Our Ref: Y/87/19/HH

**Town & Country Planning Act 1990 (as amended)
Town & Country Planning (Development Management Procedure) (England) Order 2015
Application for Planning Permission for Works or Extension to a Dwelling**

Development Single storey rear extension

Location 8 Mill View Road Yapton

TITLE
Proposed Elevations

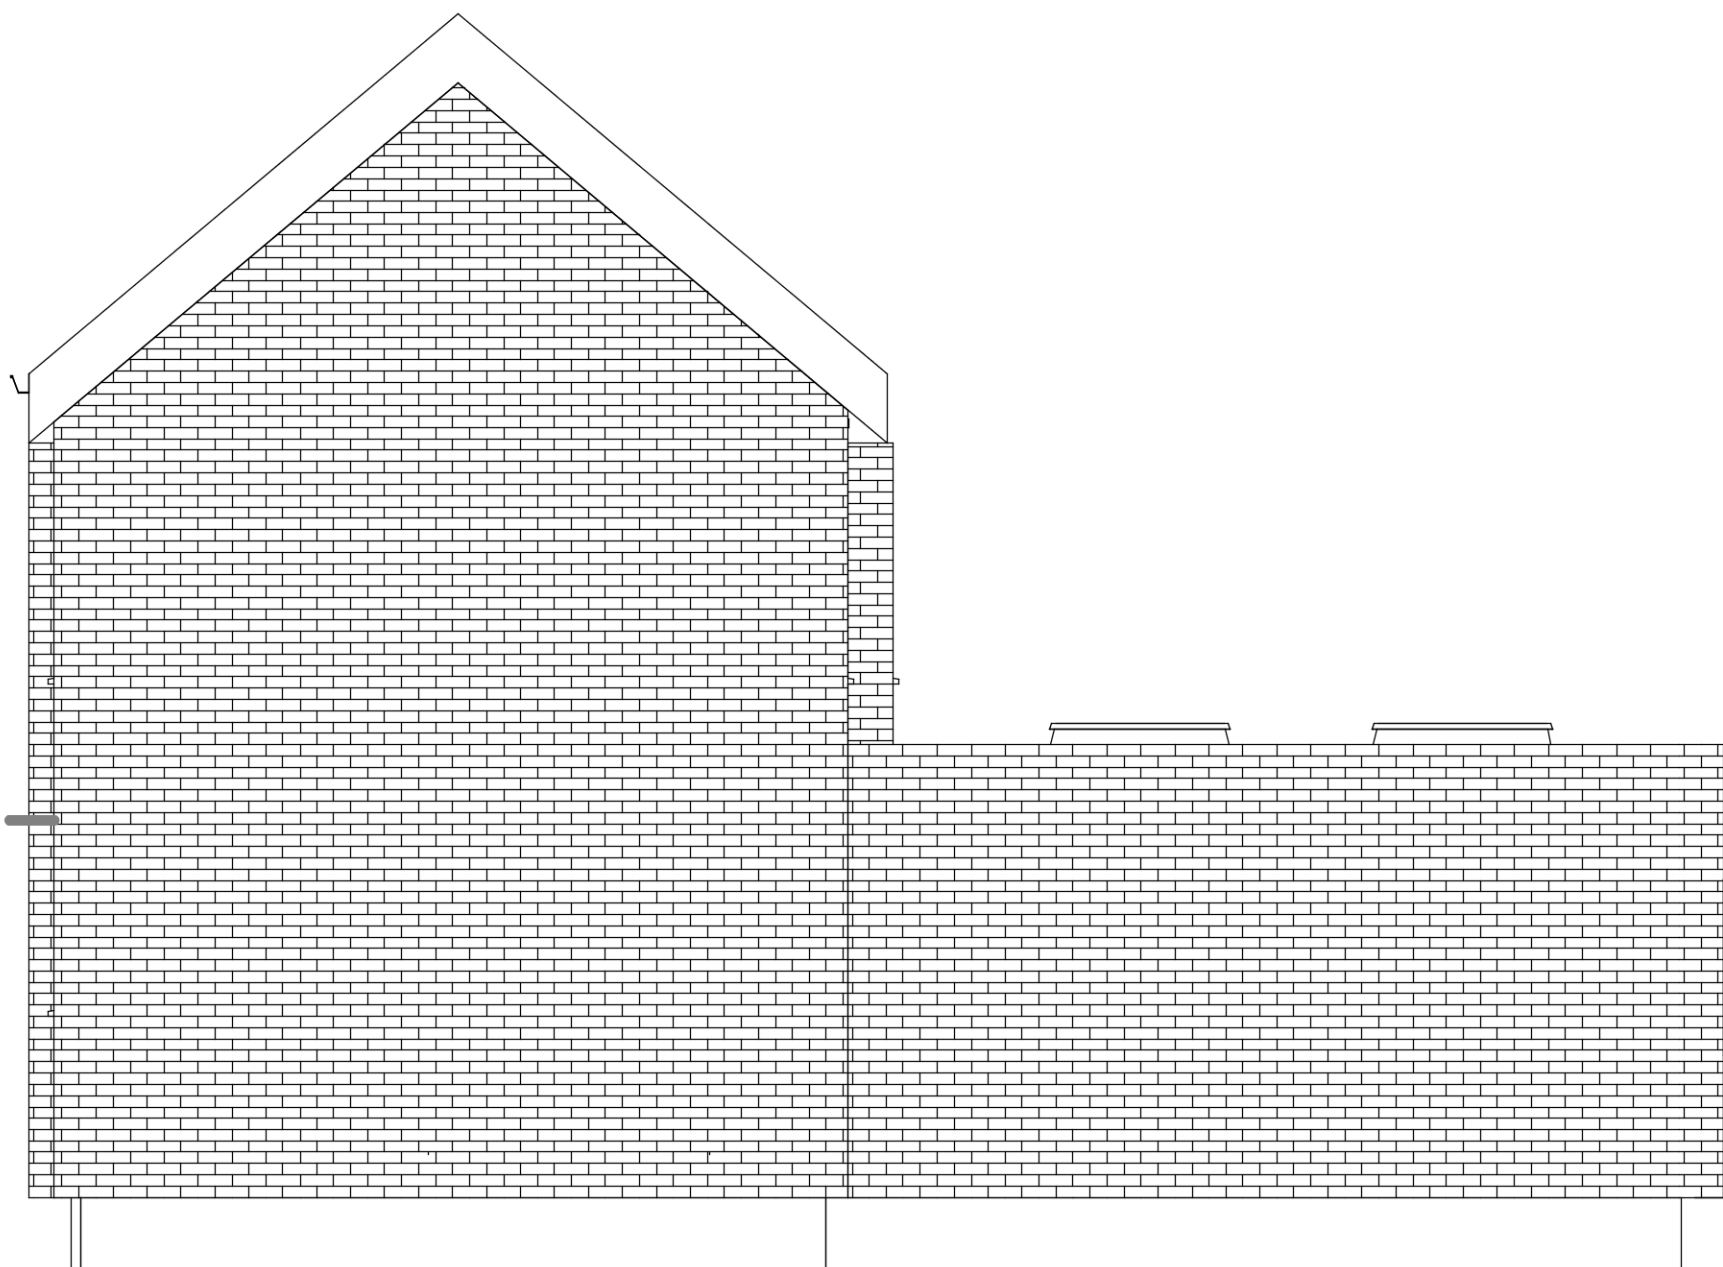
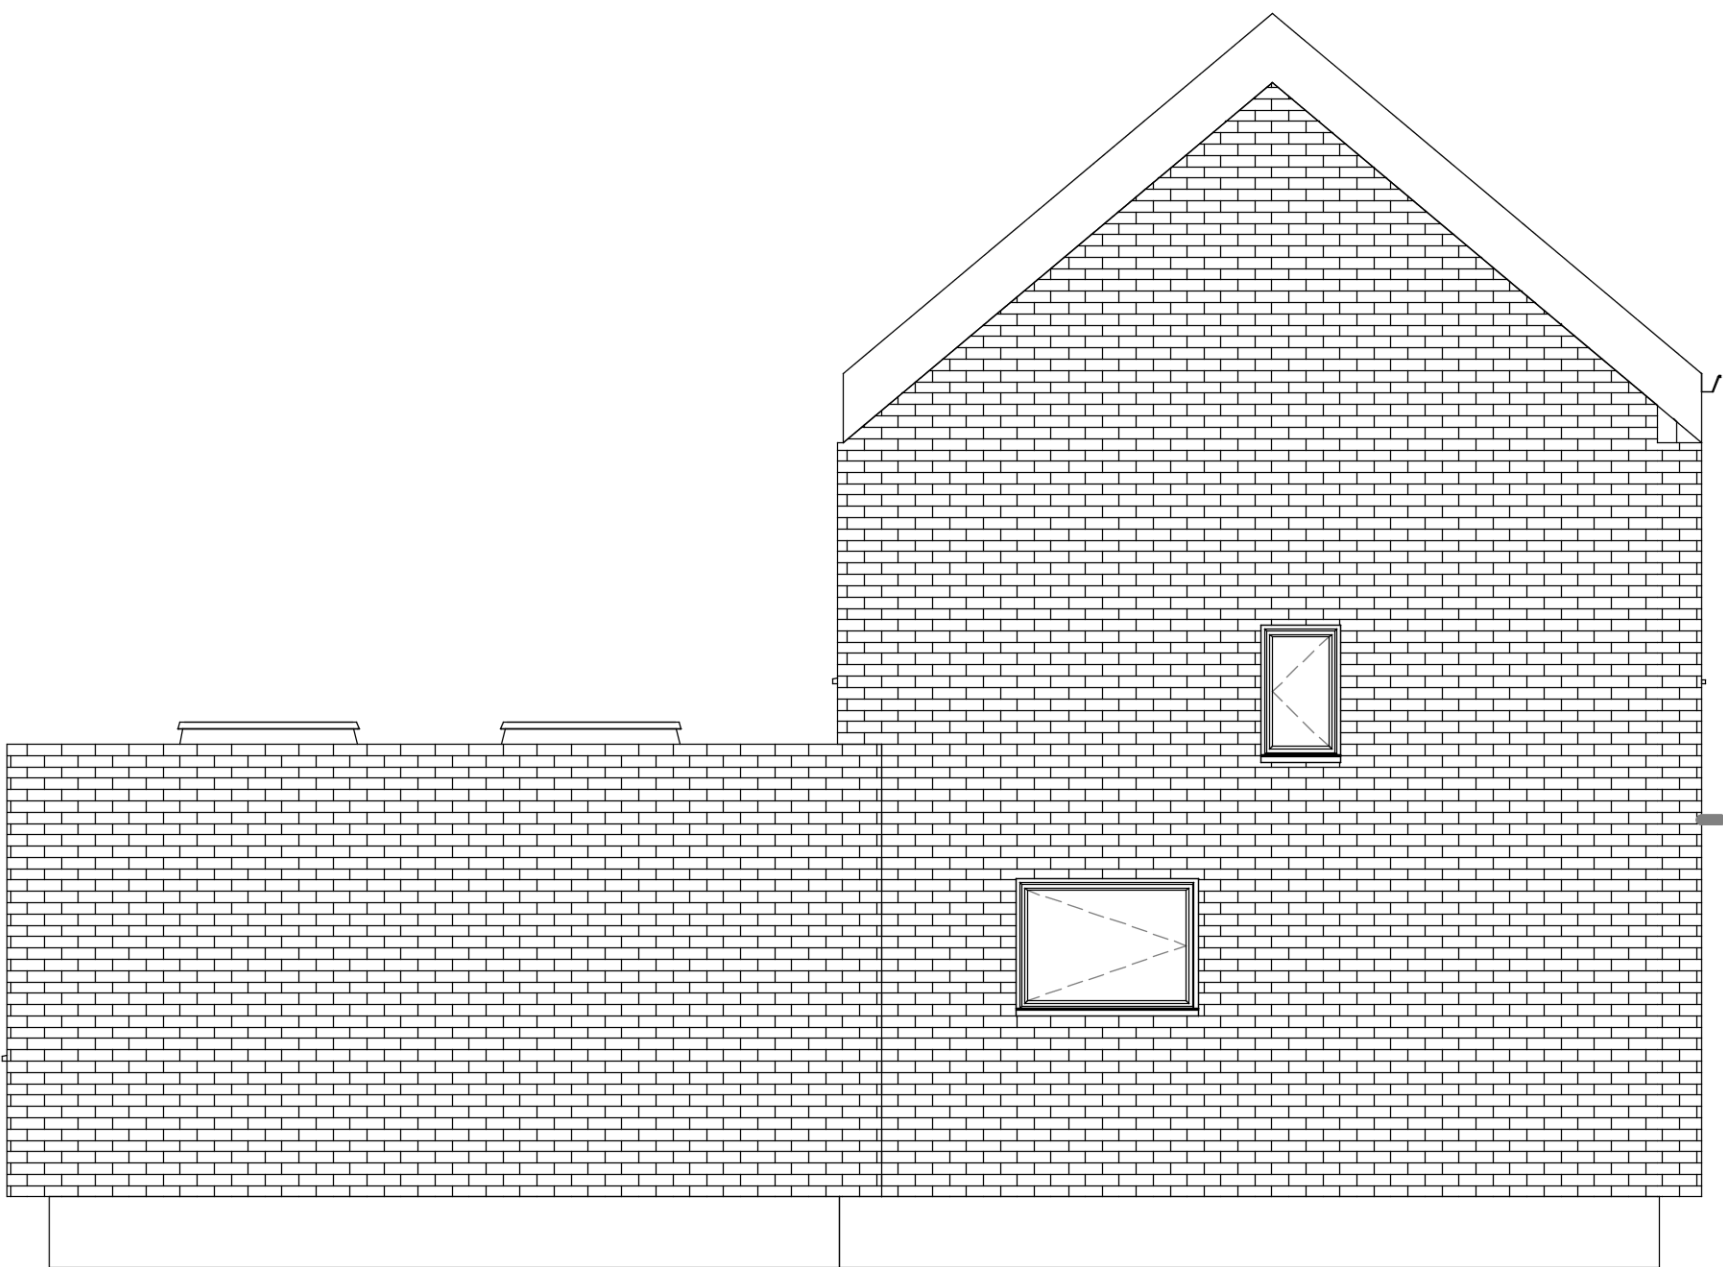
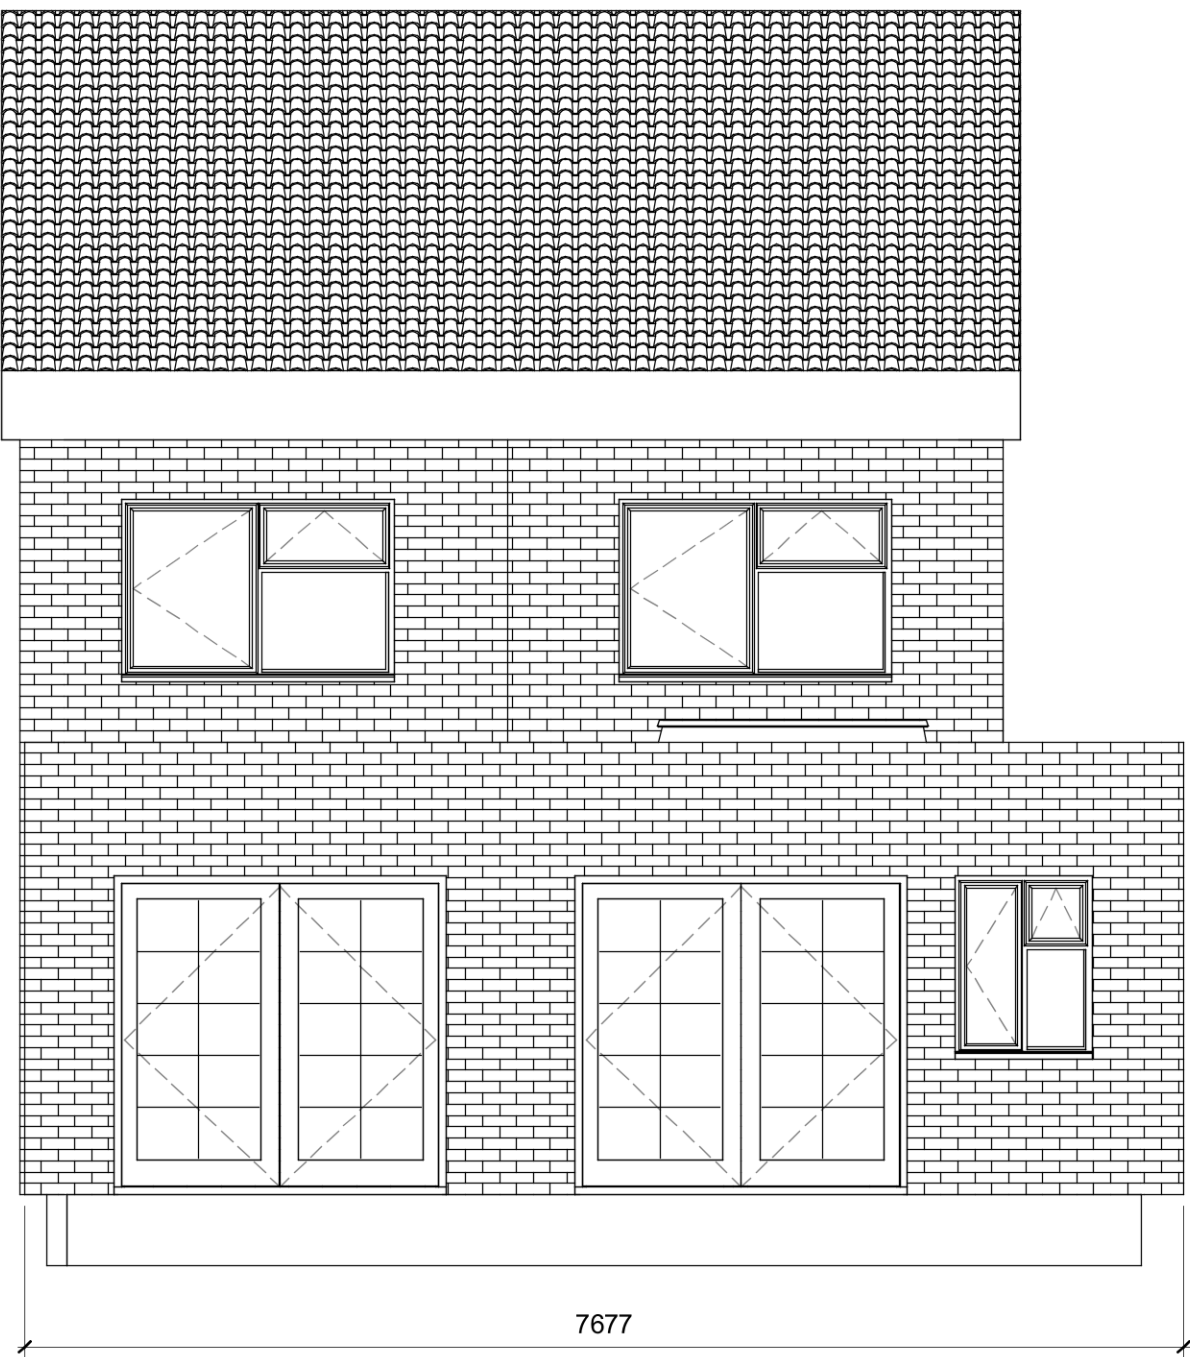
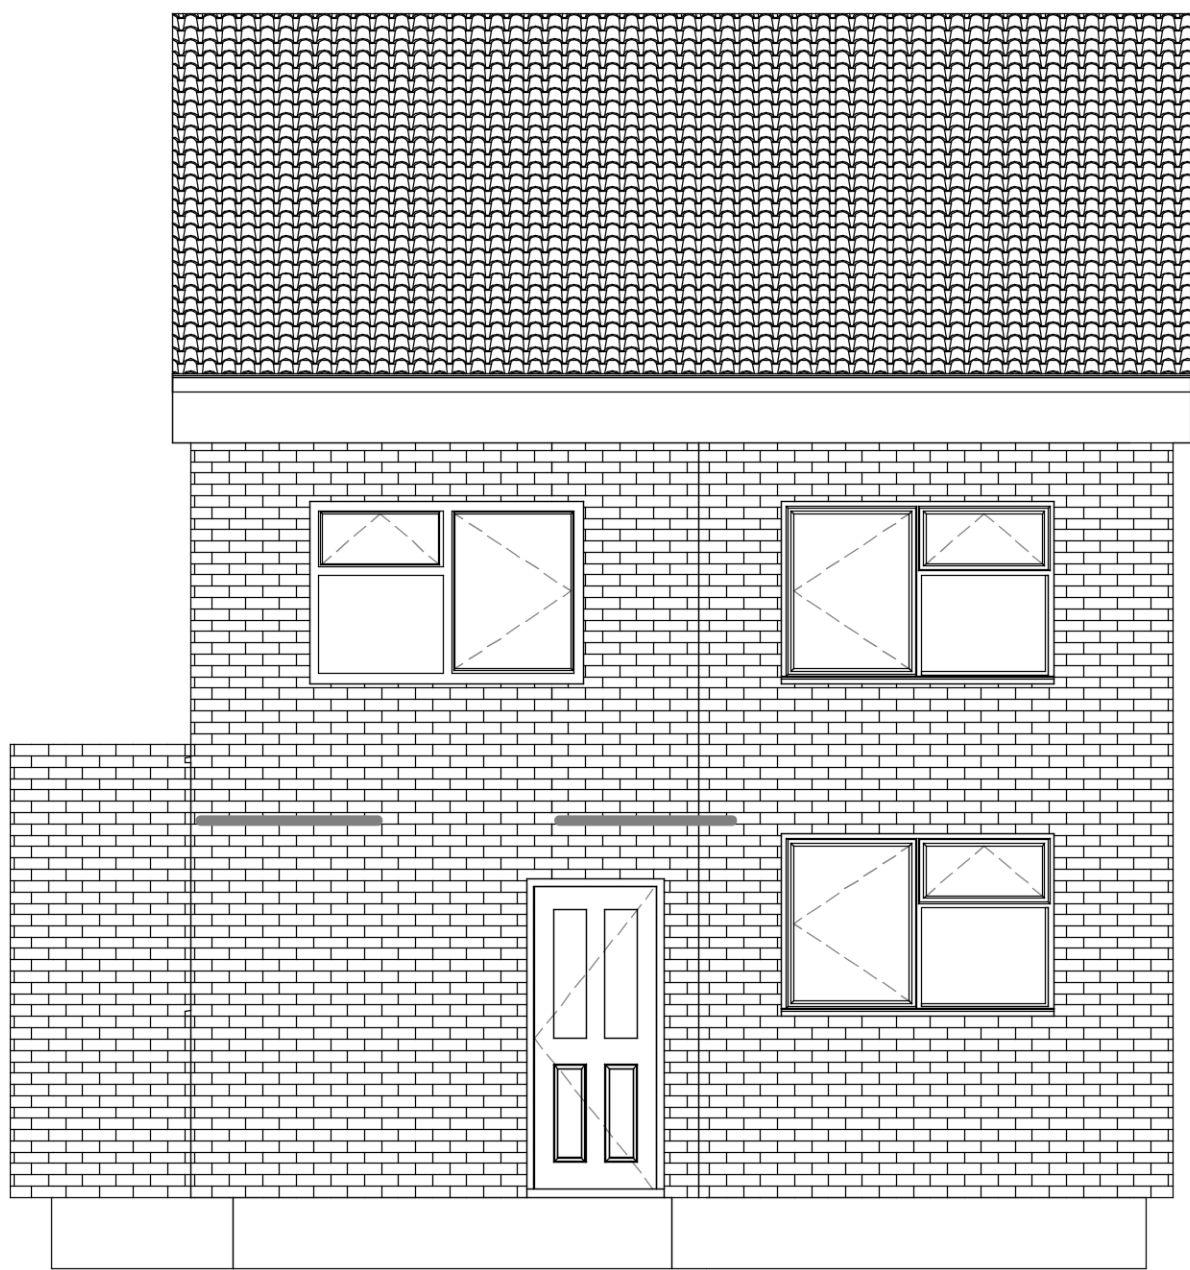
The proposed elevations do not measure correctly to the stated scale of 1:50.
